The Sizewell C Project

Natural England's response to the Examining Authority's request for further information (*Sizewell - Rule 17 request for information*, letter dated 1st October 2021 and *Sizewell C - Rule 17 request for information by Deadline 10*, letter dated 6th October 2021)

Planning Inspectorate Reference: EN010012

12th October 2021

DRAWING NO:
SZC-SZ0100-XX-000-DRW-100205

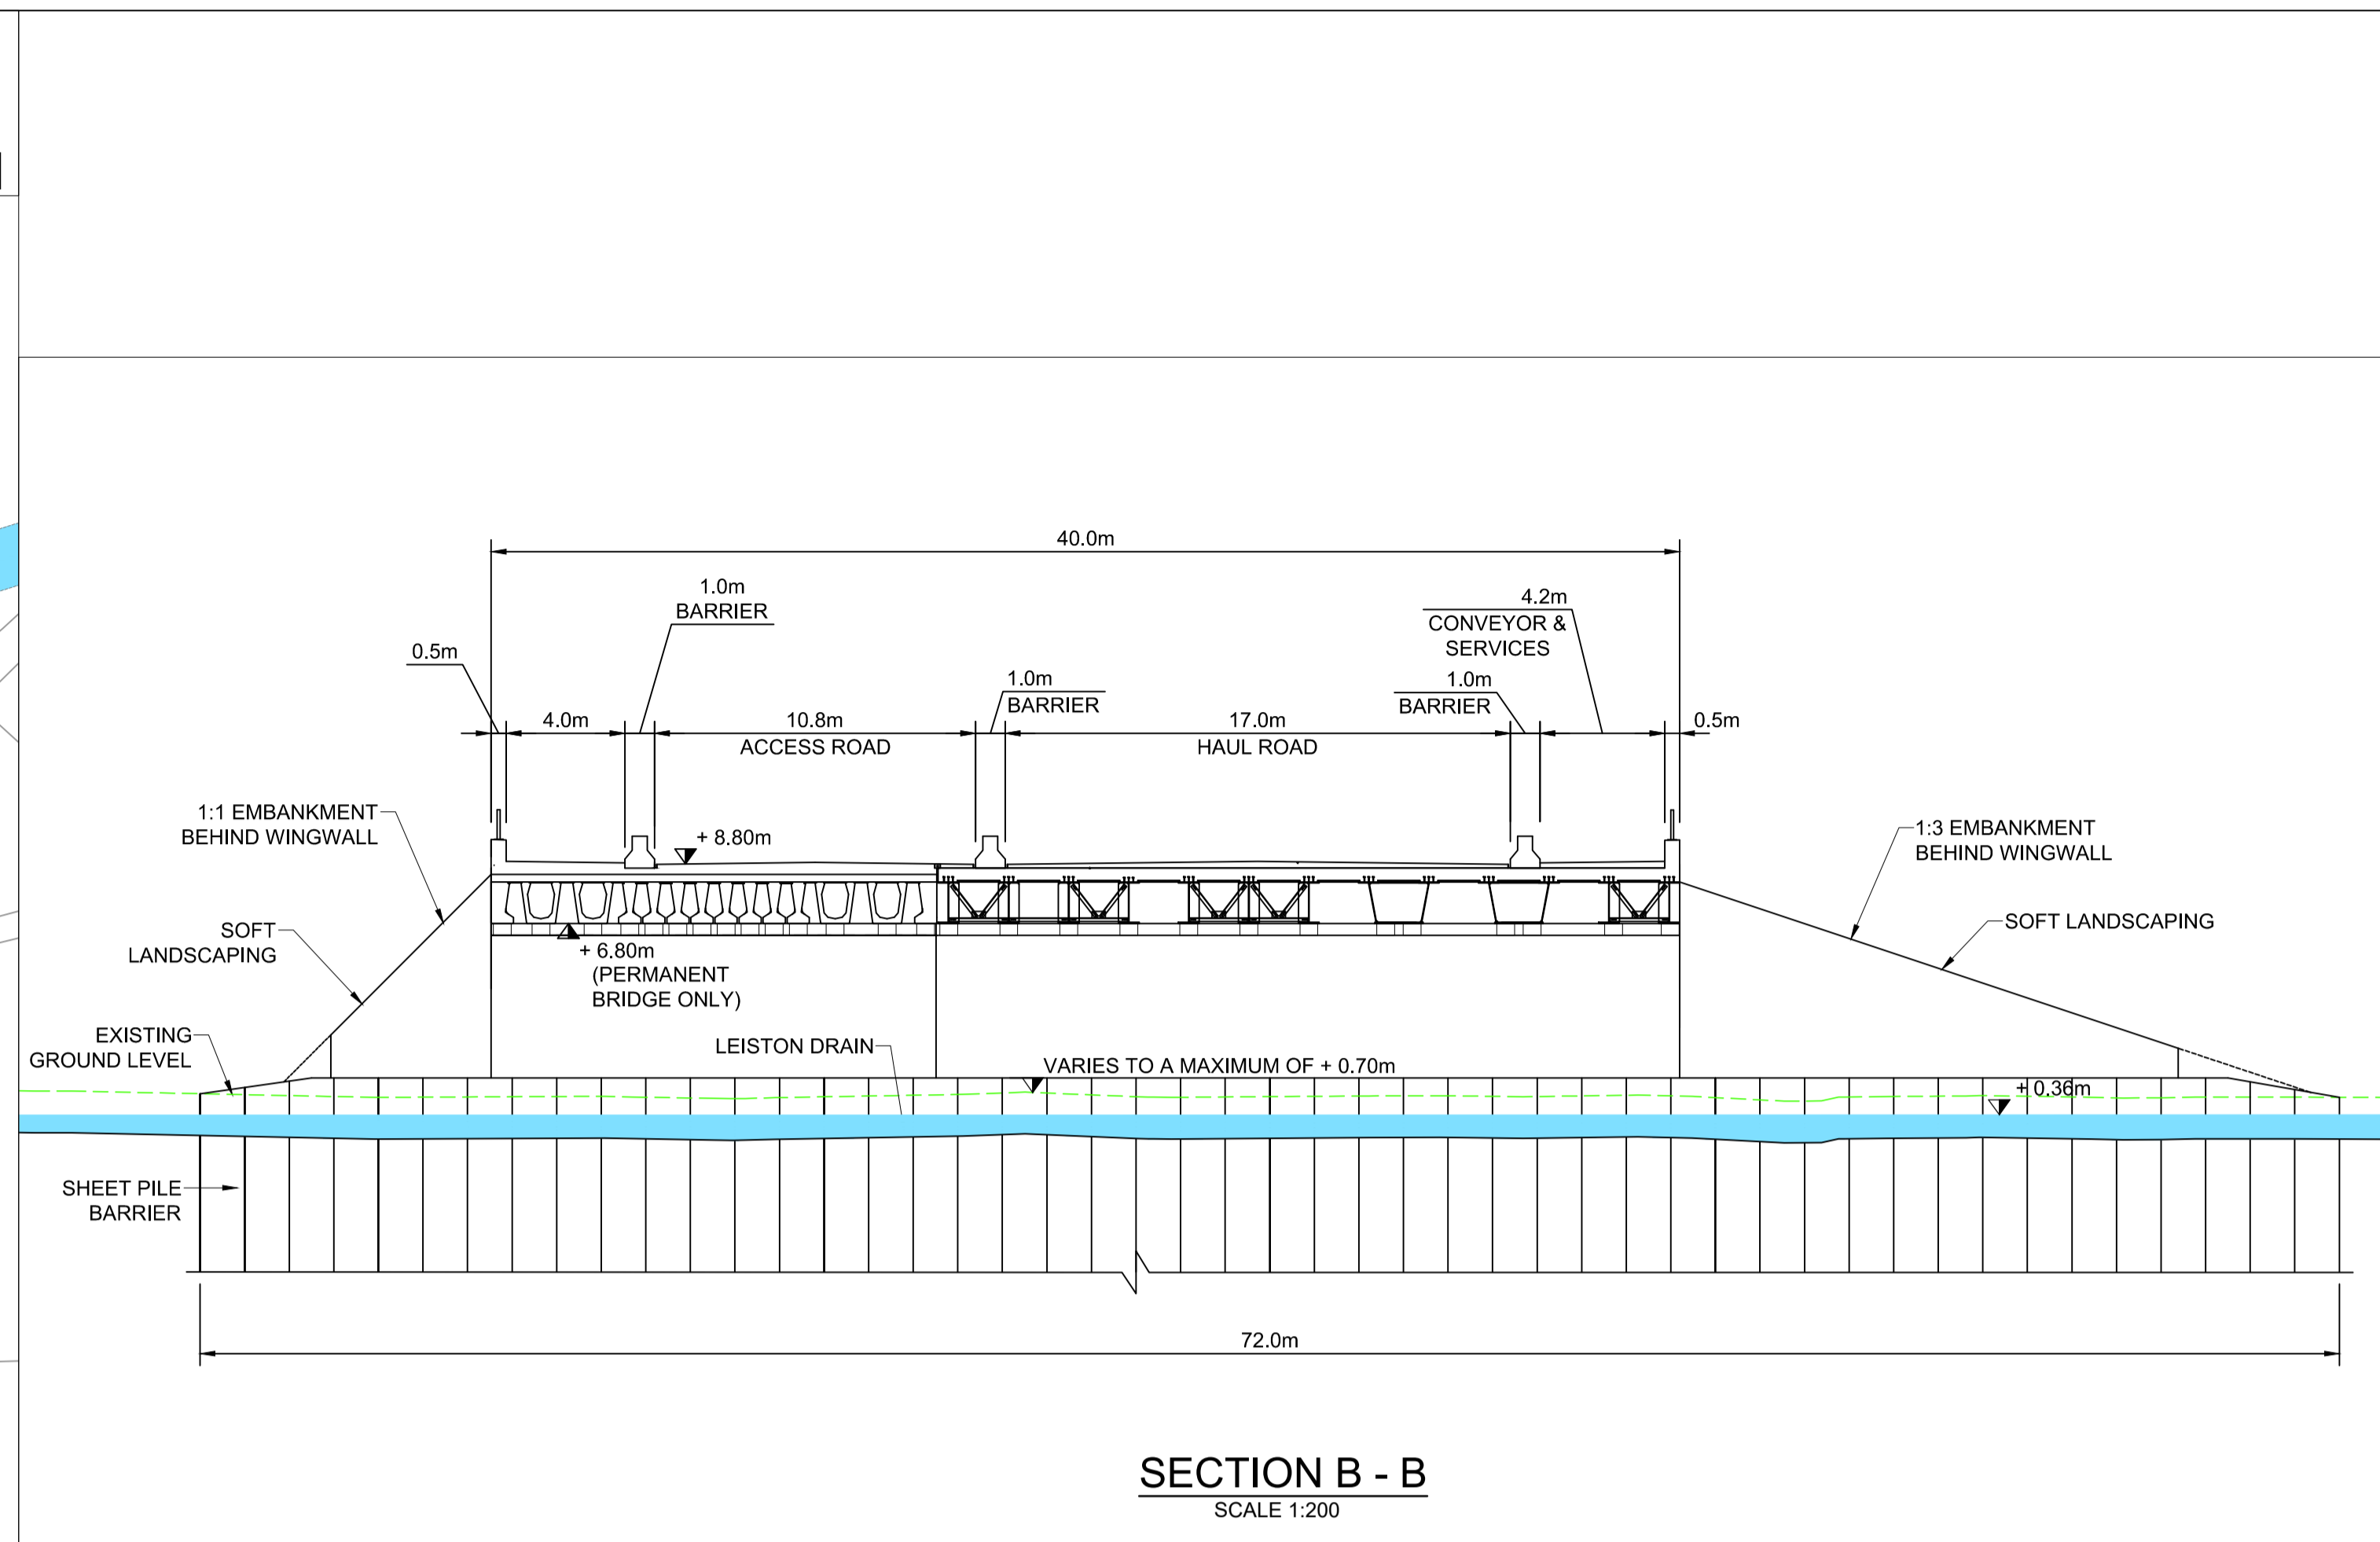
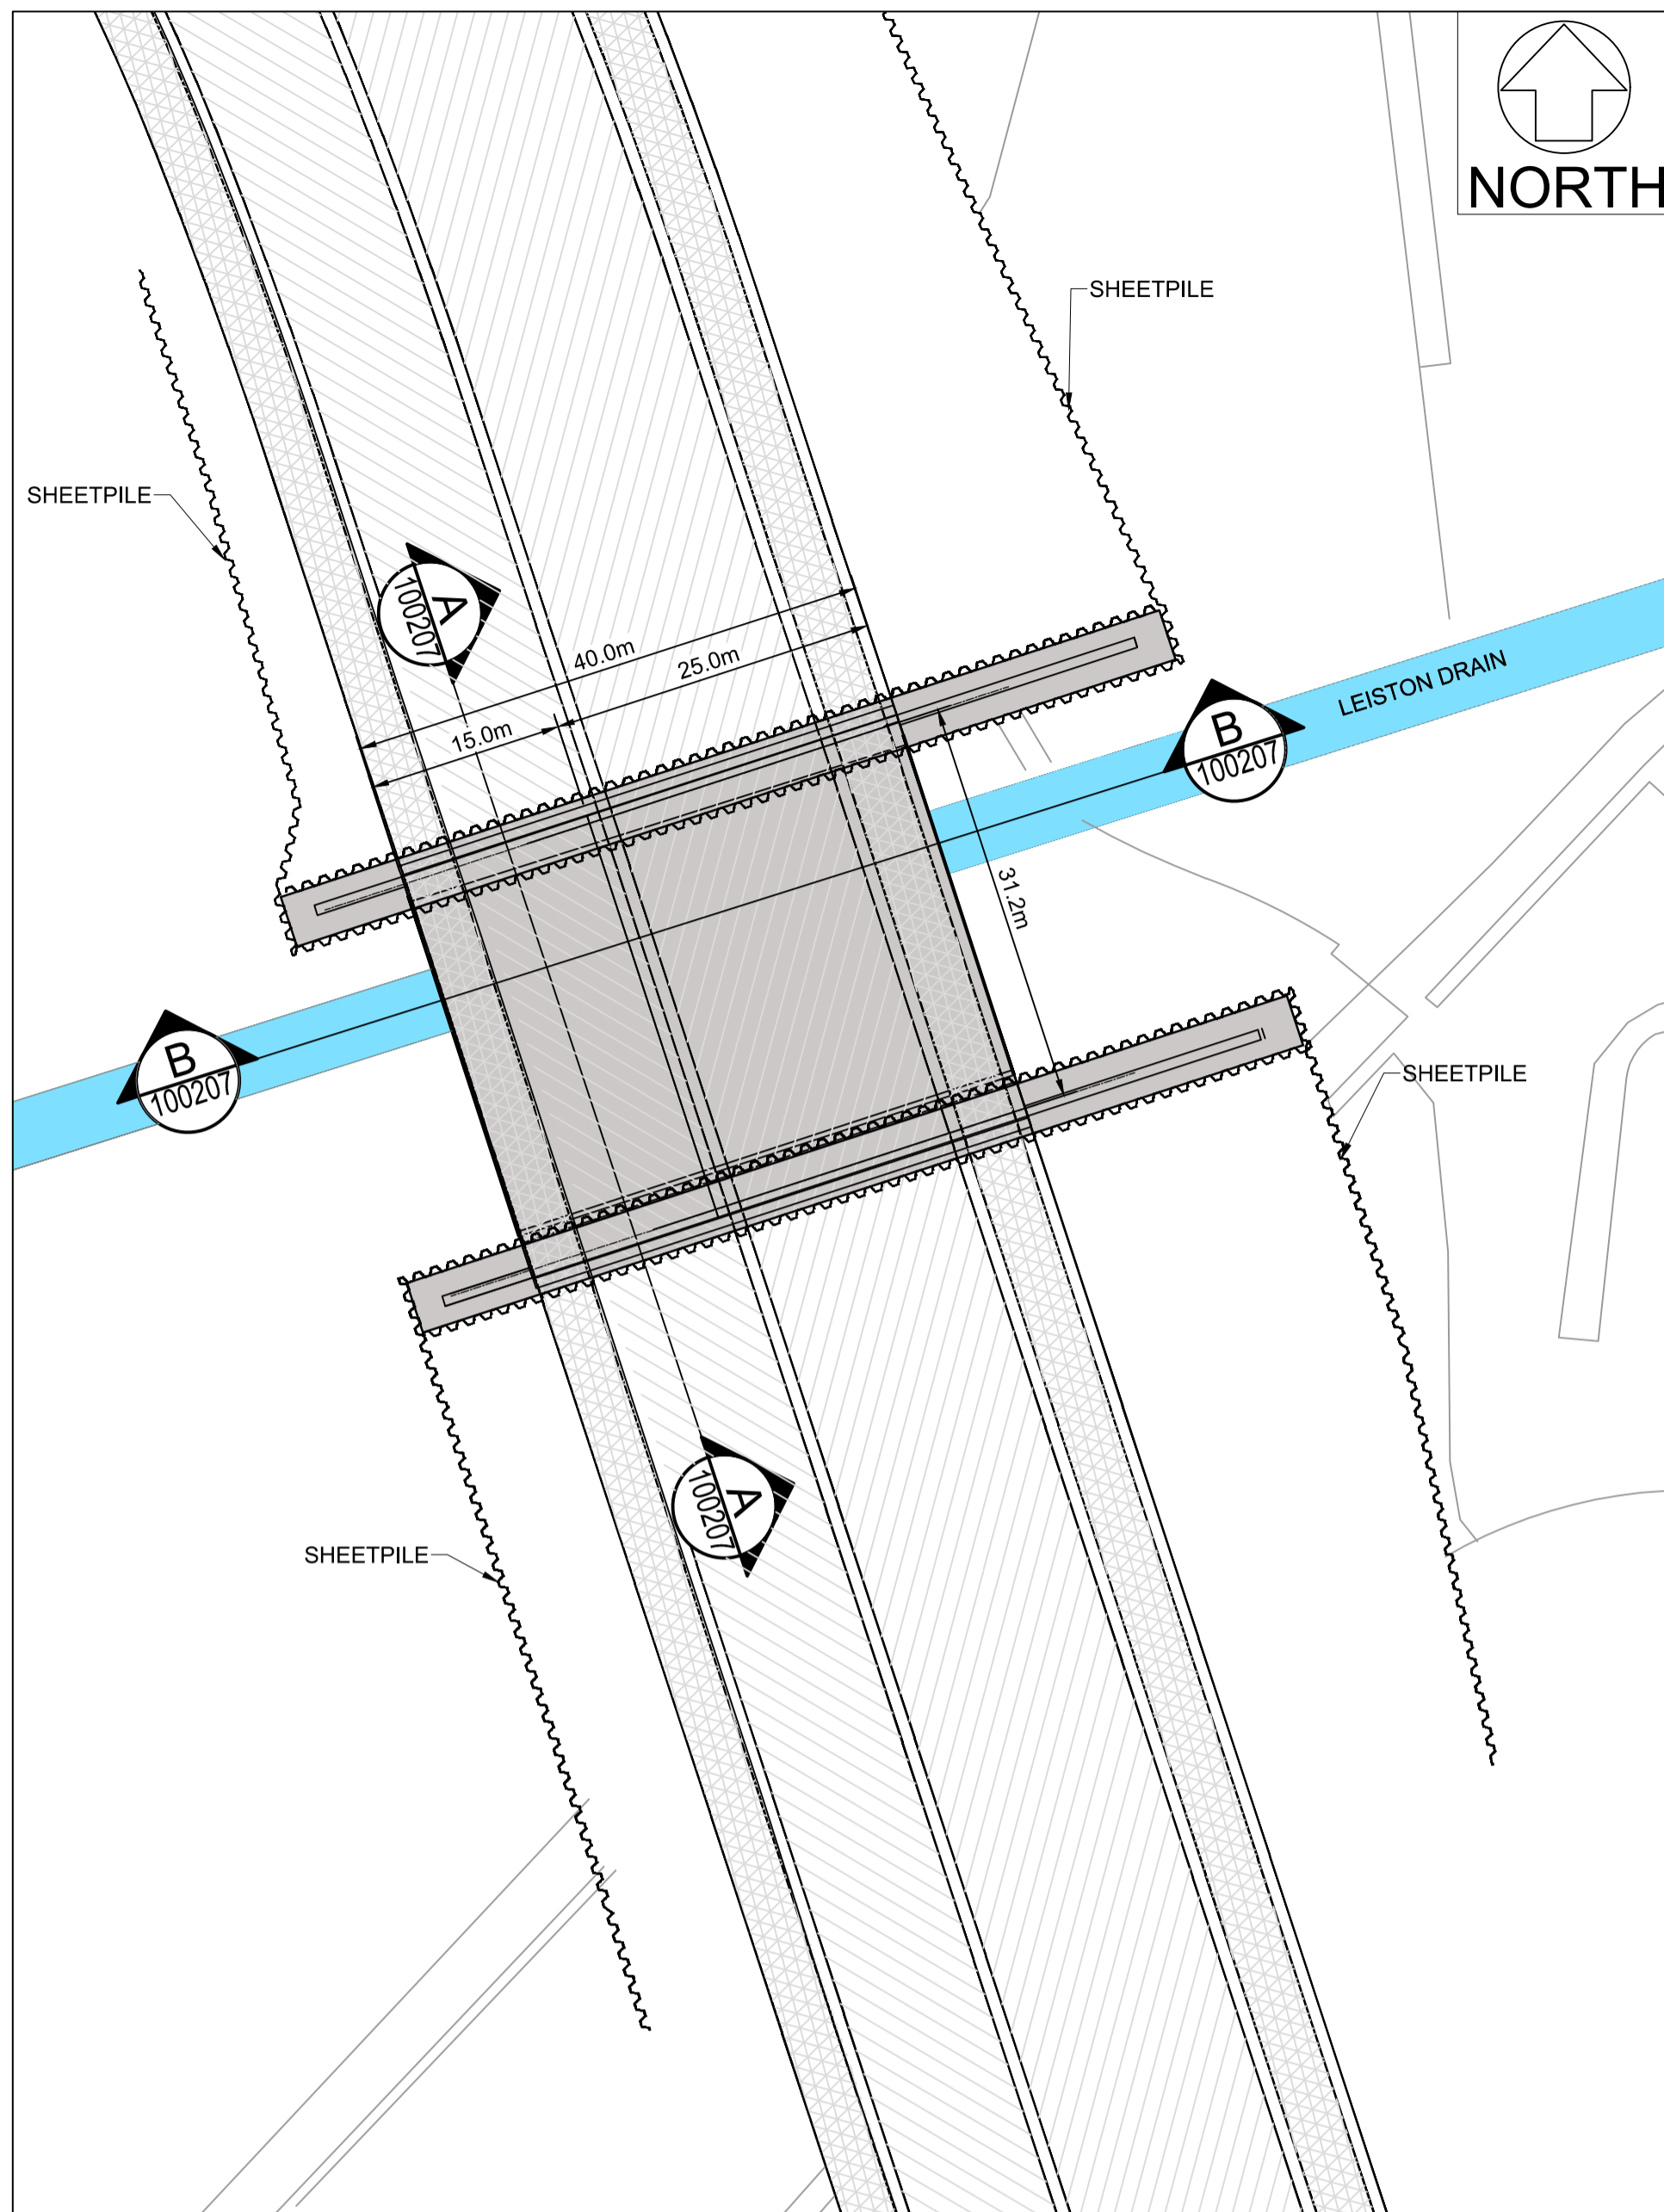
13	<p>Issue 48 – SSSI crossing effect on tall herb fen and lowland ditch systems. Natural England are recorded as being of the view in August – the latest view expressed - that should the current design and the new mammal culvert be considered justifiable against possible alternatives the quantity and quality of tall herb reed fen and lowland ditch systems created at Aldhurst Farm satisfy them “in principle”. Please can SoCG record what Natural England consider to be the possible alternatives.</p>	<p>The latest comments from Natural England on this issue within our SoCG (August 2021) is as follows:</p> <p><i>We welcome the continued optimisation of the SSSI crossing design and that while our preference remains for a three-span bridge we acknowledge that the current design represents a best alternative. However, this issue will remain ‘amber’ as we still believe that the three-span bridge design will have the least impact ecologically on Sizewell Marshes SSSI.</i></p> <p><i>We also welcome steps taken to increase connectivity between Aldhurst Farm and Sizewell Marshes SSSI using a mammal culvert.</i></p> <p><i>Should these be considered justifiable against possible alternatives, then we are satisfied ‘in principle’ with the quantity and quality of tall herb fen (reedbed) and lowland ditch systems created as compensation at Aldhurst Farm.”</i></p> <p>To clarify, the ‘possible alternatives’ as outlined above refers to the three-span bridge design option presented in pre-application for the SSSI crossing itself rather than the mammal culvert on Lover’s Lane. Natural England reiterate our point made above and throughout our pre-application advice, Relevant and Written Representations with regards the SSSI crossing design proposals against possible alternatives.</p>
